Date 09 December 2019

**RE: 6/2019/1788/COND – Former Shredded Wheat Site, Broadwater Road, Welwyn Garden City, AL8 6UN**

Thank you for re-consulting us on the above application for the submission of details pursuant to condition 5 (Surface water Discharge) 6 (Drainage System) 52 (Provision of open space/play space) 35 (Delivery of accessible Housing) 13 (Highways) 37 (Vehicle access Point to Pall Mall Site) 50 (Refuse Storage Arrangements) on planning permission 6/2018/0171/MAJ, at Former Shredded Wheat Site, Broadwater Road, Welwyn Garden City, AL8 6UN.

Dig Title: **PROPOSED CONSTRUCTION DETAILS PHASE 1**

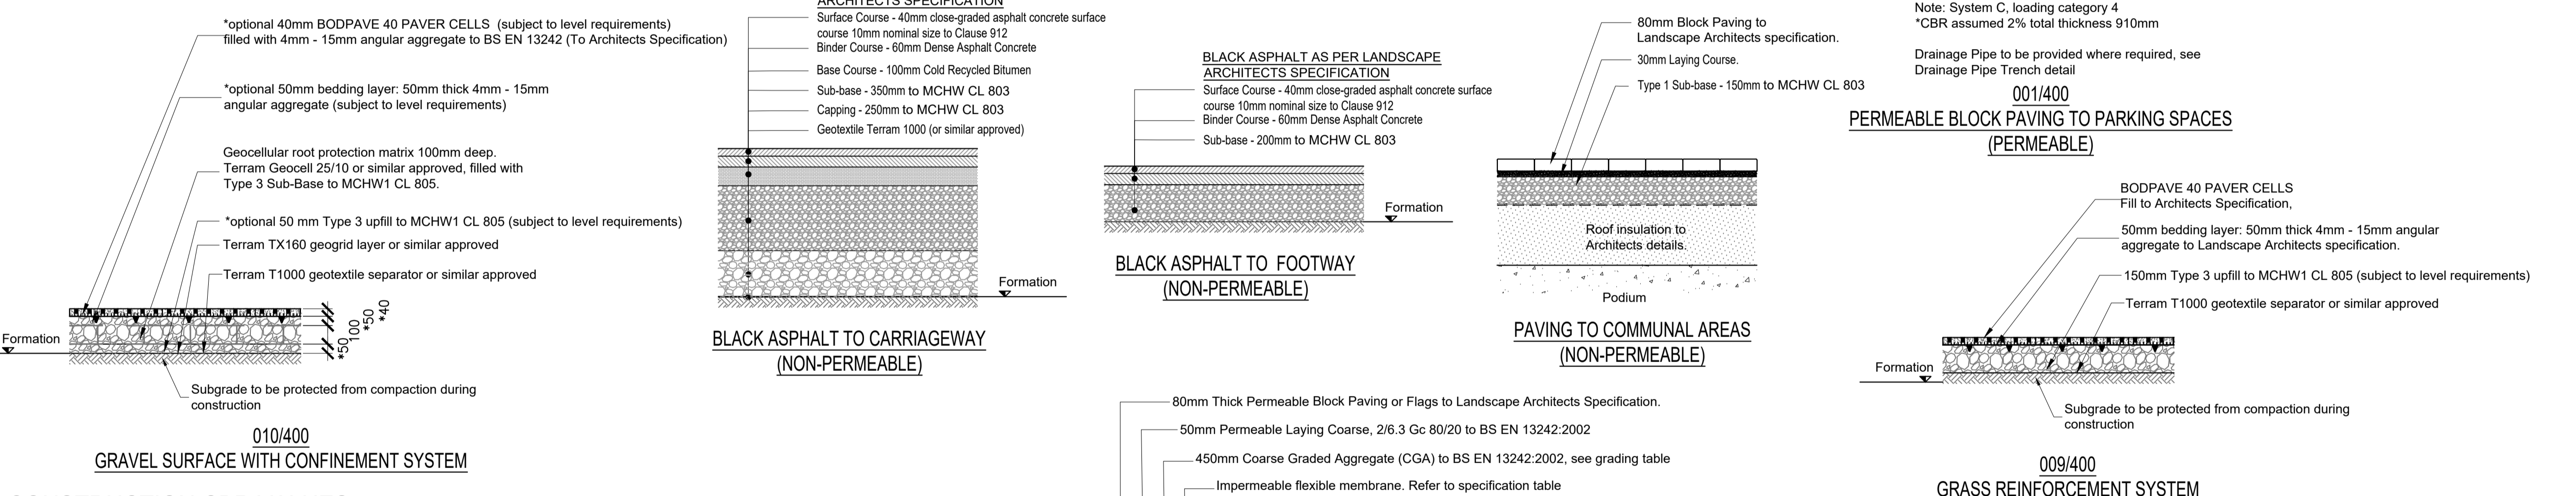
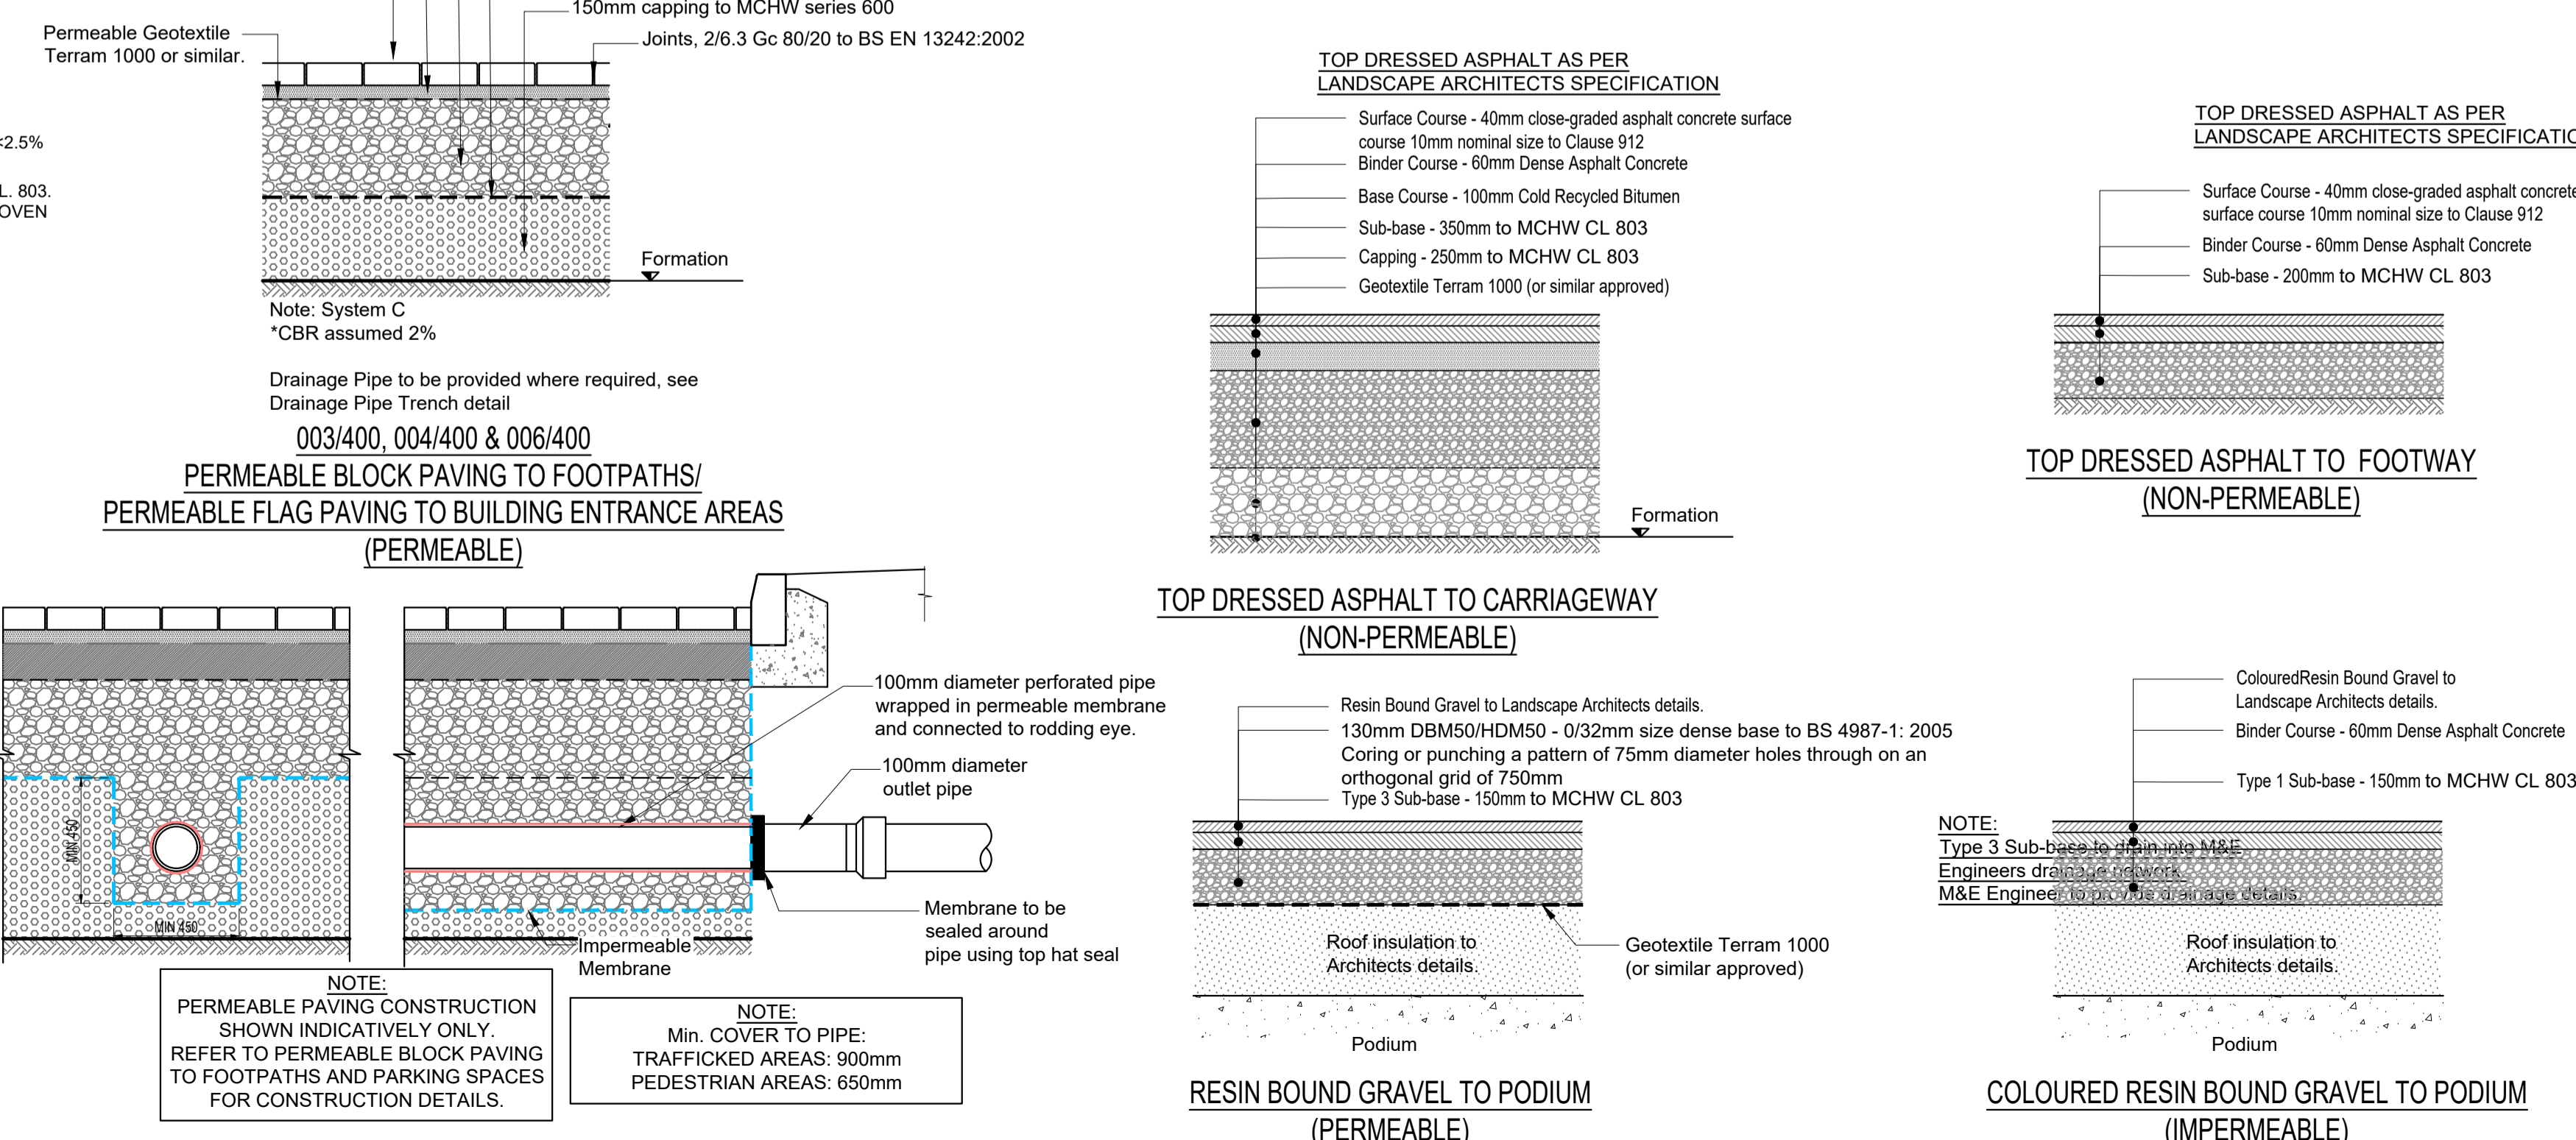
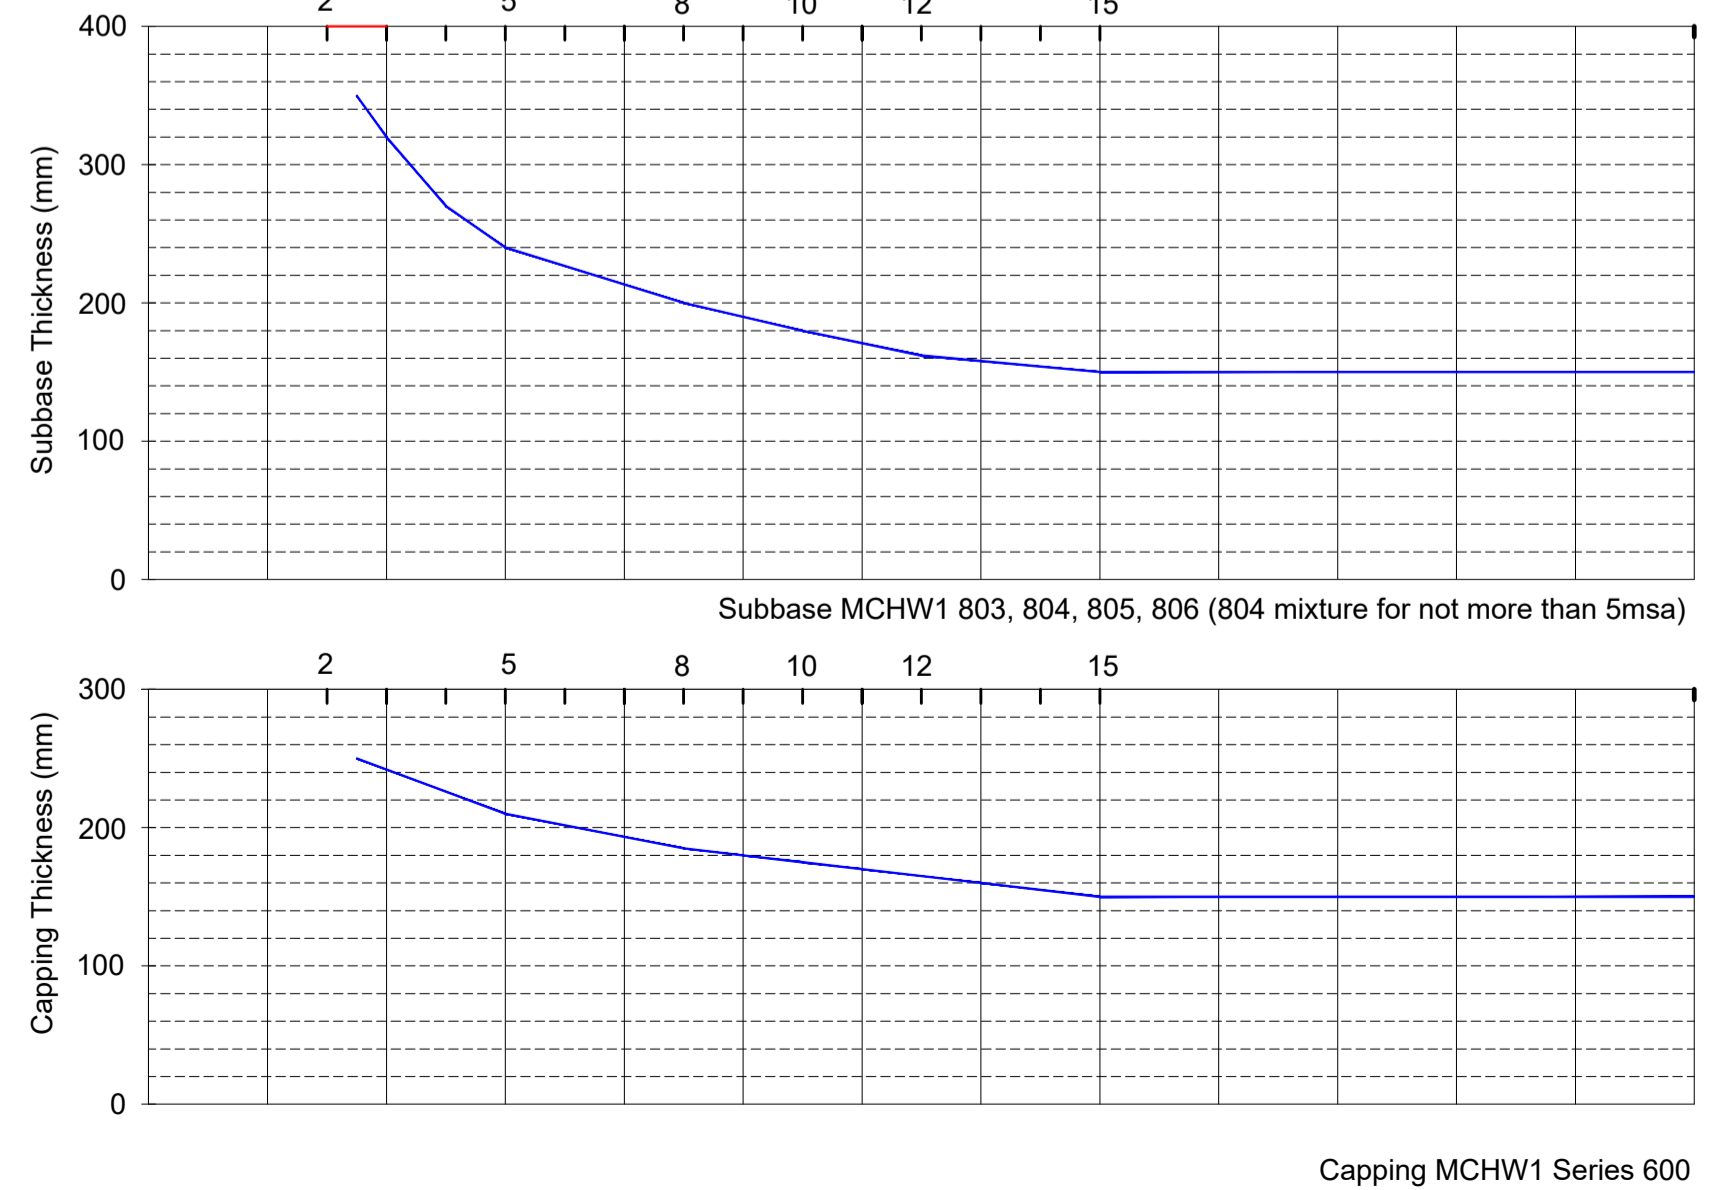
Based on the assessment of the submitted information, no detailed engineering drawings of the proposed tanks and dry swales have been provided.

Details for the swales can be seen on drawing 066571-CUR-00-XX-DR-C-98008. The attenuation tank is a proprietary feature and detailed design is to be carried out by a third party when appointed. We have provided a performance spec on the drawing that would allow a third party to carry out this design. This is normal practice.
